2210737

Huntlee – Stage 1 MP10_0137 Modification 20 – Response to Request for Further Information

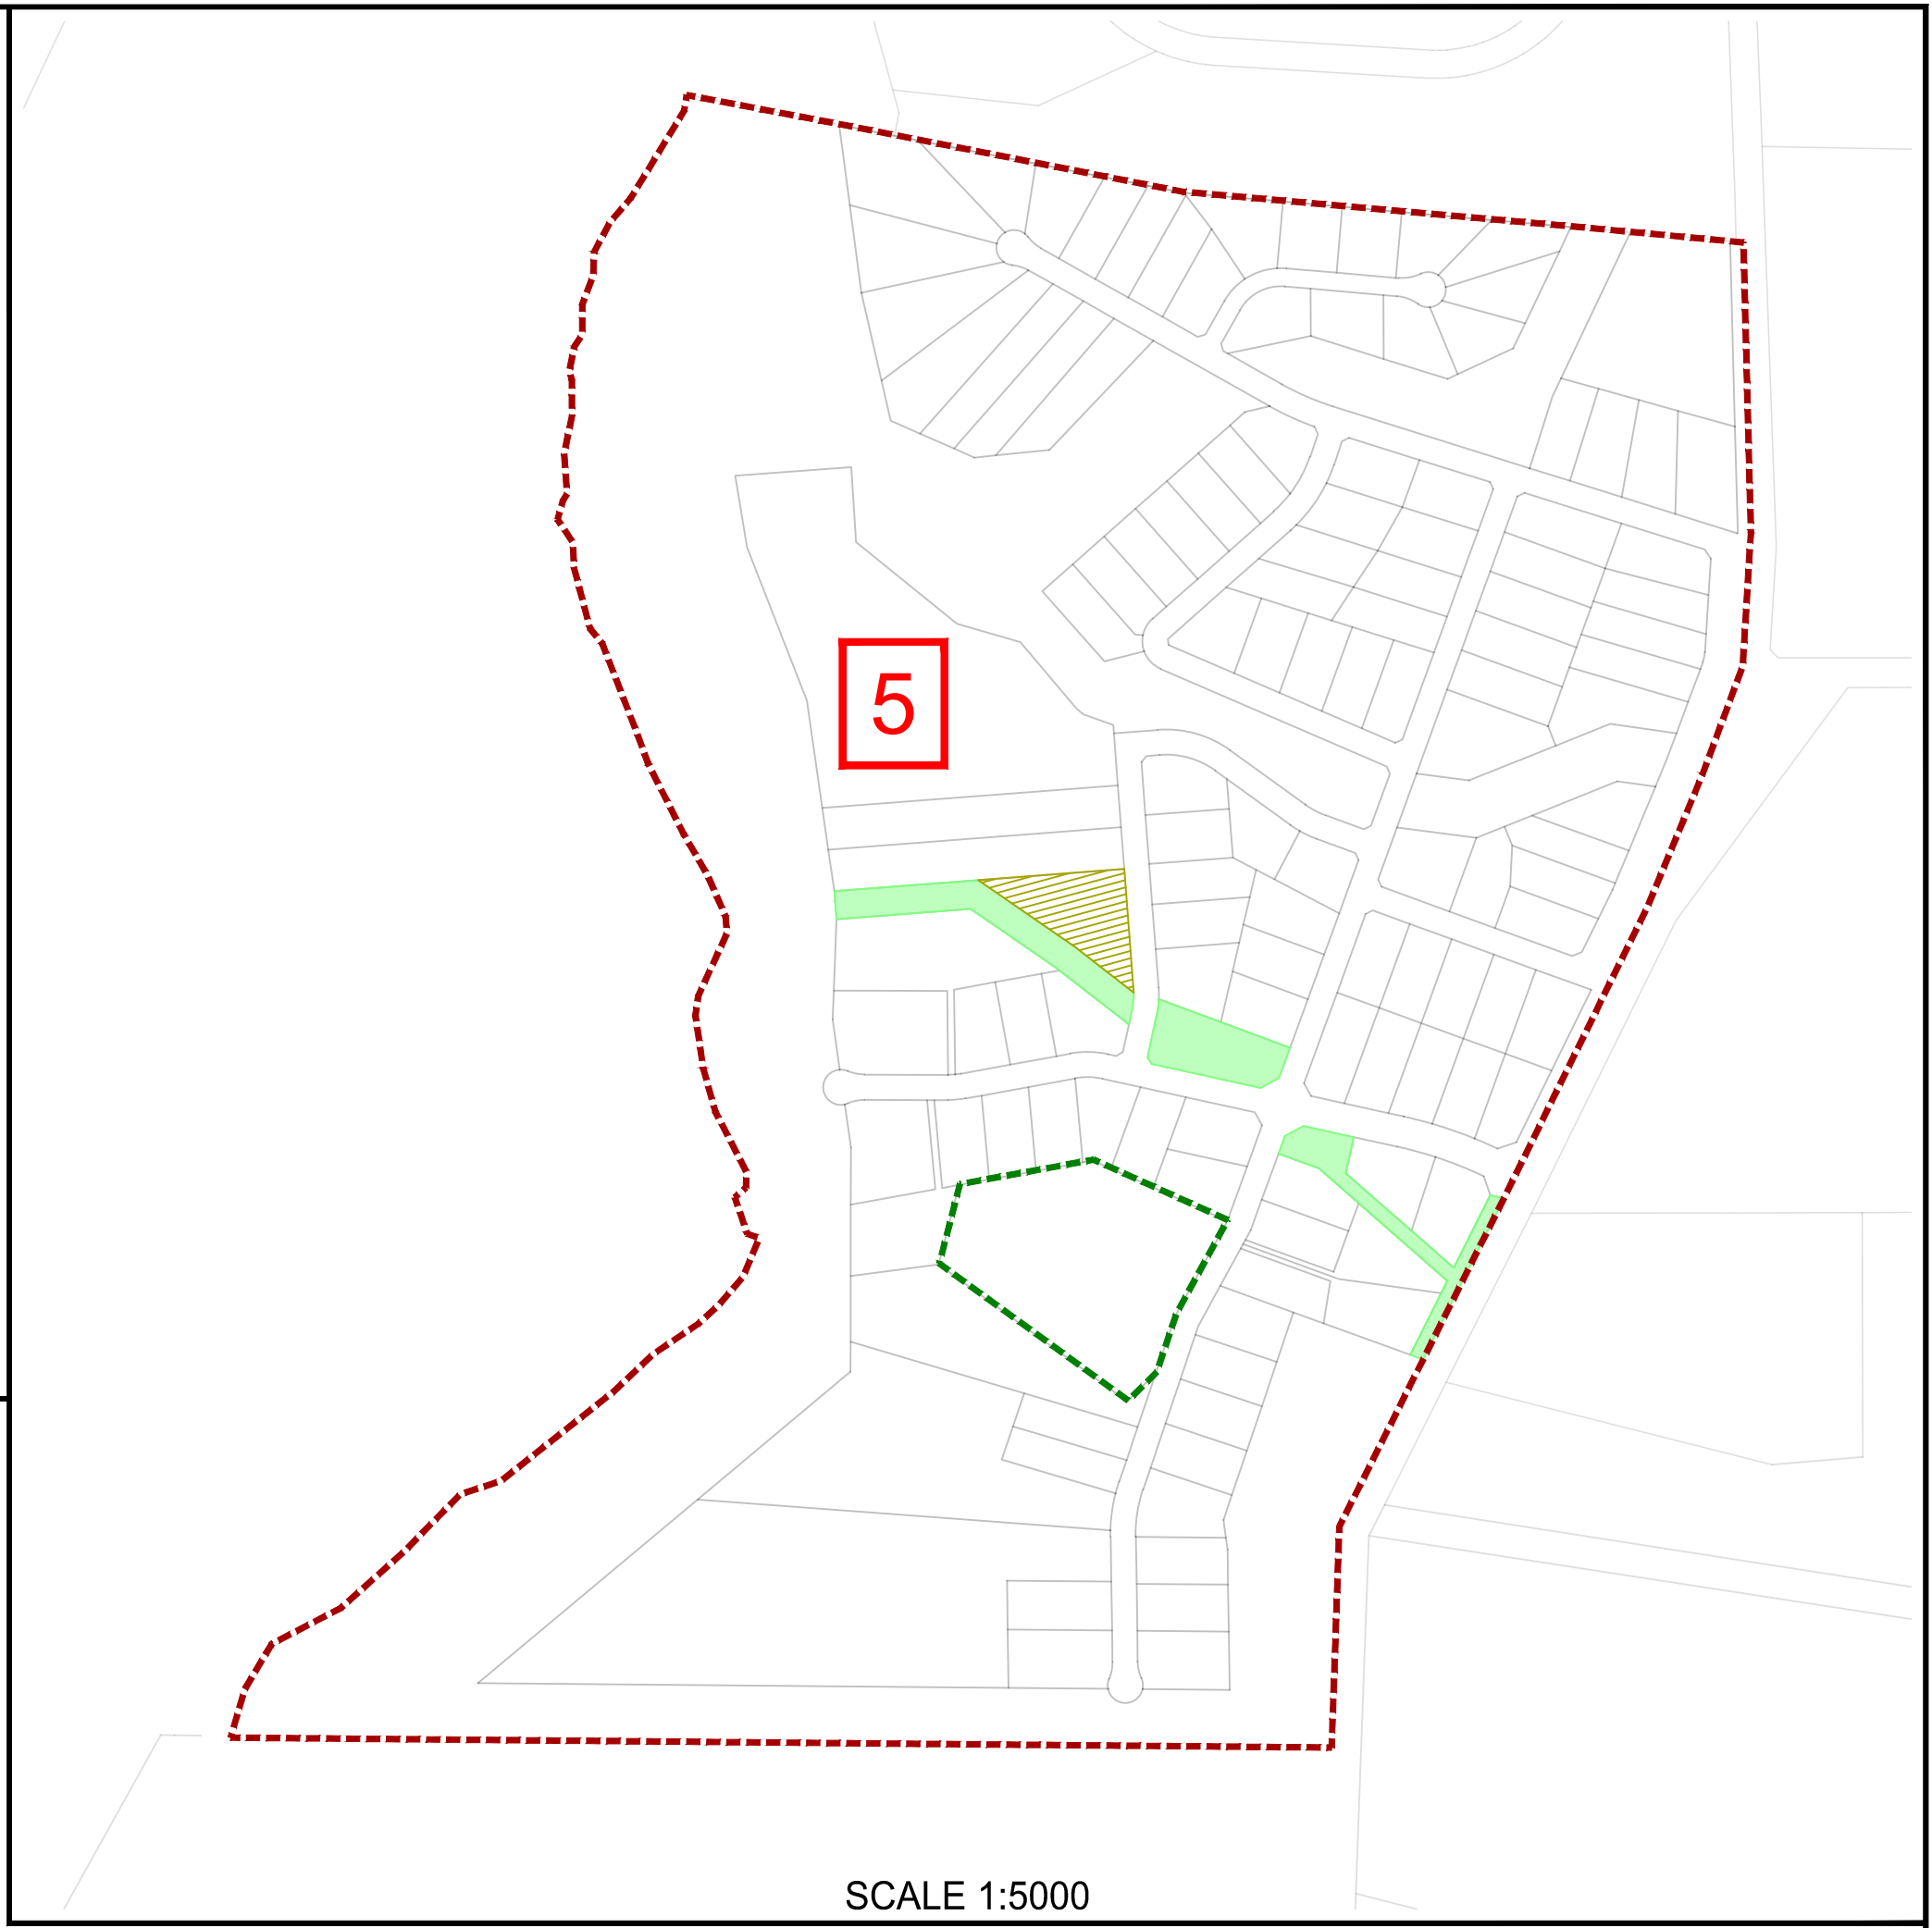
Due to discussions with Cessnock Council in relation to open space and landscape embellishments, the community hub area as proposed in the original submission of Modification 20 is proposed to be removed and located outside of the Stage 1 Project boundary, which is understood to be Council's preference (noting Council's submission on Modification 20 indicated the shape and configuration of some open space may result it in being unfit for purpose with further consultation needed). Huntlee Pty Ltd have also confirmed that the amended Community Hub aligns with the amended Council VPA plans, currently under discussion with the relevant Council officers.

The previously proposed Community Hub Lot 1178 (being an infrastructure, community and education lot) is now proposed to be subdivided into four commercial/mixed use lots. These changes are provided below.

The removal of the Community Hub lot results in changes to the open space provisions as proposed, with public open space increasing by 0.04ha, and the Community Hub reducing the overall quantity by 1.2ha.
